**Consultation Response from KC,  
Conservation & Design**
**2023/92825 156, Northgate, Almondbury, Huddersfield, HD5 8US**
**Erection of rear extension (within a Conservation Area)**
**Date Responded: 23.10.2023**
**Responding Officer: S Pickles**
**Responding Ref:**

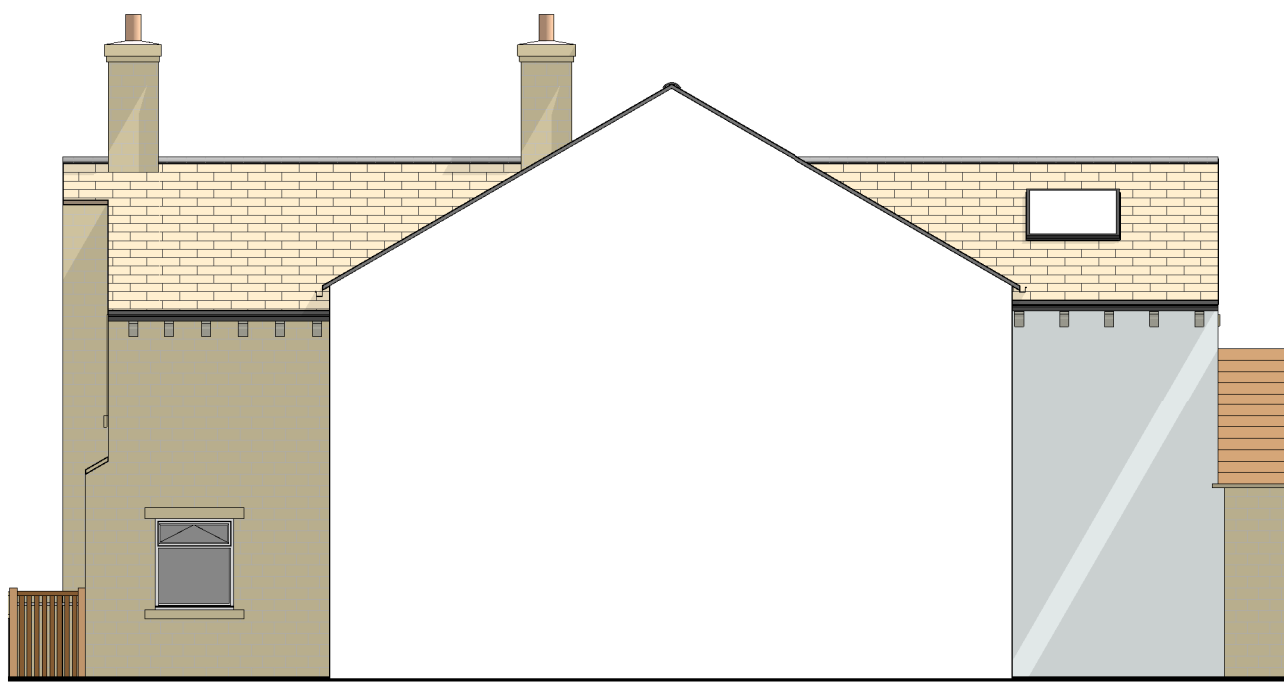
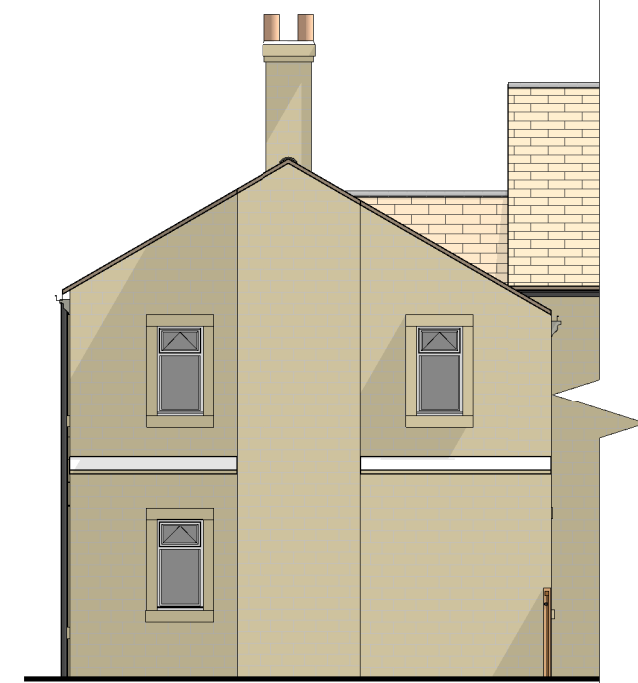
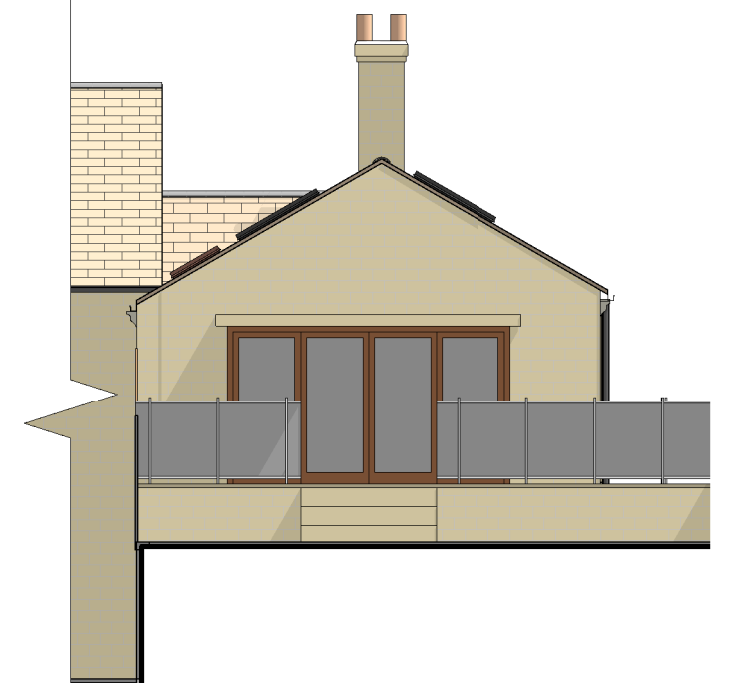
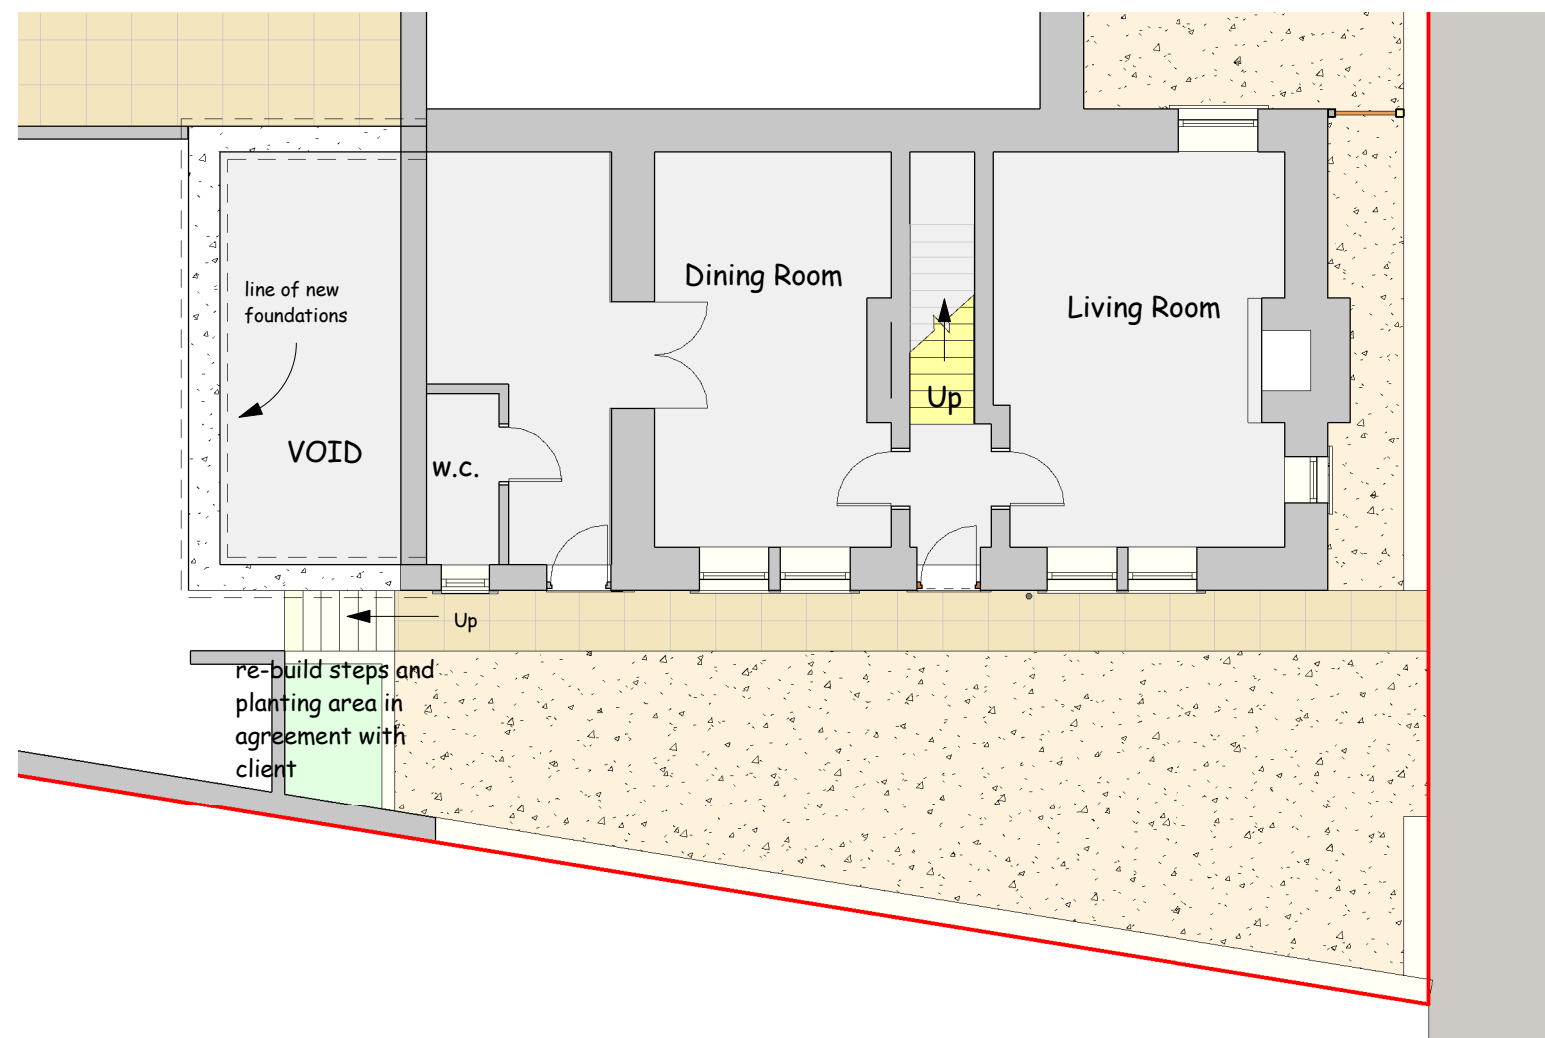
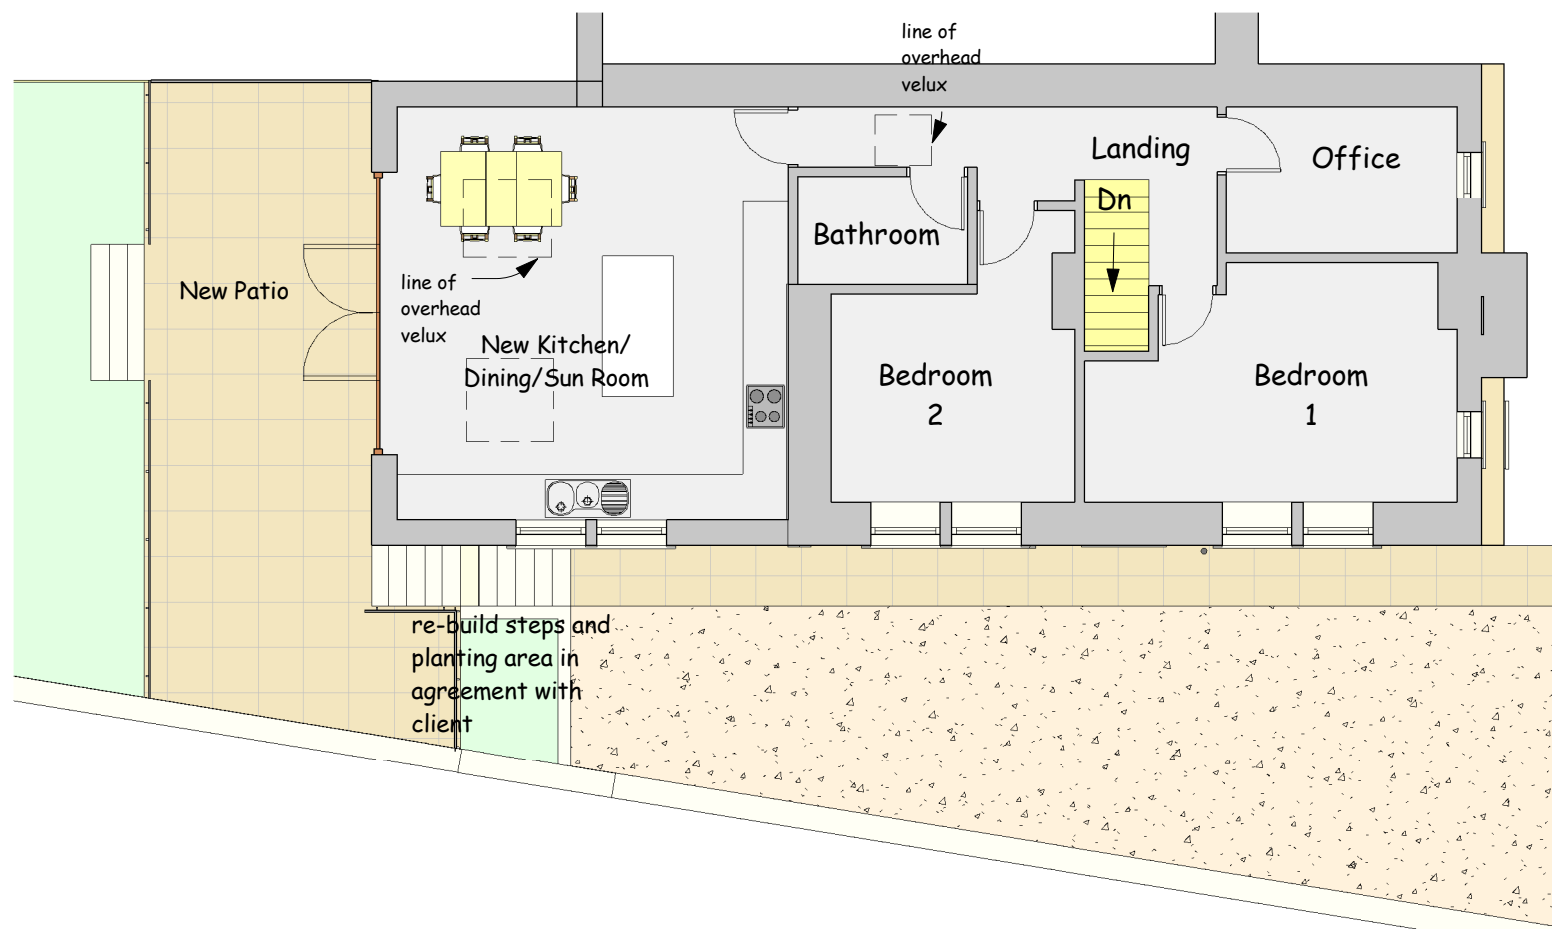
The proposals are focused on the western side of the property. As existing there is a modest single-storey, lean-to extension. Looking at the mapping the extension does appear to present on the 1893 mapping. The proposals are for the demolition of the lean-to extension and the construction of a larger 2-storey extension. The extension is not set down or back but would match up with the roof line and the elevation of the property.

The extension would see the erection of a much larger extension, which would be clearly visible. In addition to the extension, it would see the upper terraces developed with a large patio area, which would include building up sections of wall and the erection of a glazed balustrade.

As proposed Conservation would raise an objection to the extension and associated works. It would see the loss of the historic extension which is modest and does not create a visual draw. The proposed extension would form a dominant feature which while making use of matching (similar)

materials, is not subservient to the host building and does effectively see the addition of a further terrace. The associated works would have a more urbanised feel with the addition of the large patio area and the proposed glazed balustrade. We are not convinced that the extension would meet the test of policy 72(1) of the Planning (Listed Building and Conservation Areas) Act, nor Local Plan Policies LP24 or LP35. We would equally raise that we are not convinced that the proposed extension would meet the requirements of the House Extension and Alterations SPD (2021).

We consider that it may be possible to consider some form of extension. It would however need to ensure that it is entirely subservient to the host building removes the use of the glazed balustrade and gives greater consideration to the context of the site.
